# CITY OF ALBUQUERQUE

**Re: American Toyota**  
**5995 Alameda NE, Albuquerque, NM 87113**  
**30-Day Temporary Certificate of Occupancy- Transportation Development**  
**Transportation Development Final Inspection**  
Engineer's/Architect's Stamp dated 12-18-14 (C18-D012) Cert date 04-24-18

SITE PLAN

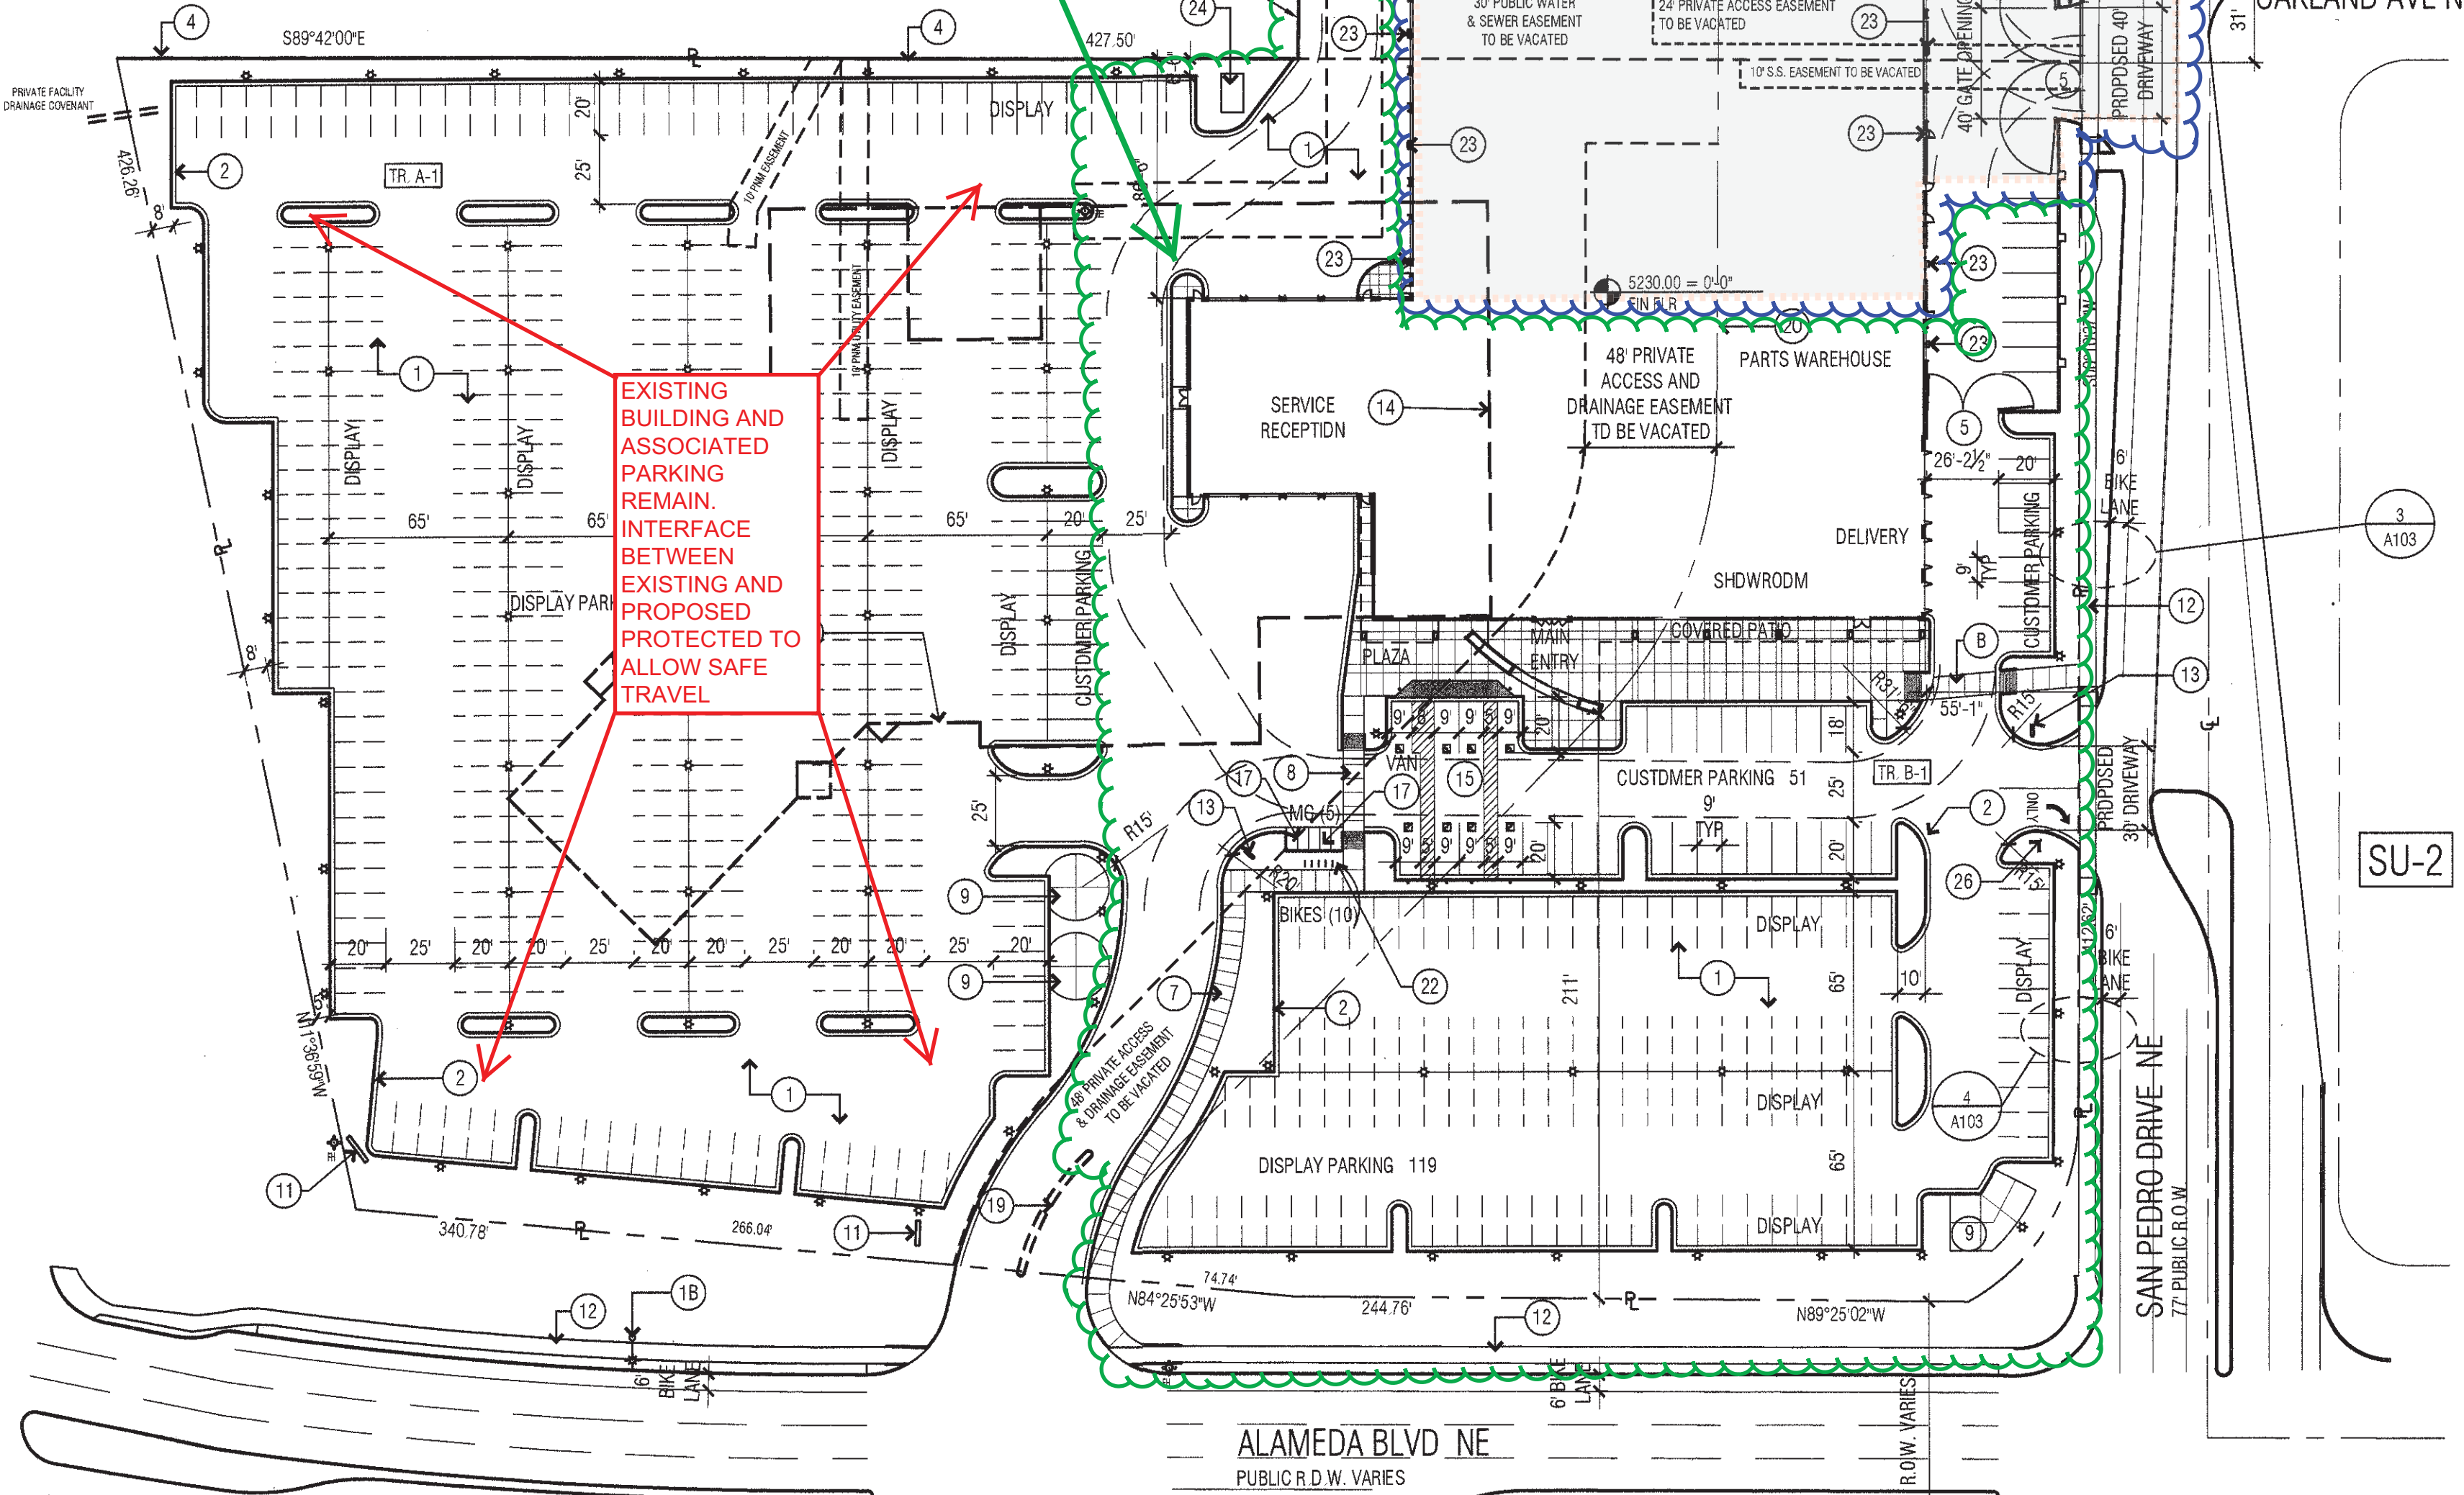
1. The ADA accessible parking sign must have the required language per 66-7-352.4C NMSA 1978 **"Violators Are Subject to a Fine and/or Towing."** If that language is present it is not visible in the detail.
2. Please add parking bumpers to the two center ADA accessible spaces where the pavement is flush with the ADA ramp.
3. Motorcycle parking spaces shall be designated by its own conspicuously posted upright sign, either free-standing or wall mounted per the zoning code.
4. Please close the unused curb cut on San Pedro Dr. at the north end of the site with curb & gutter (Standard Drawing 2415) and sidewalk (Standard Drawing 2430).
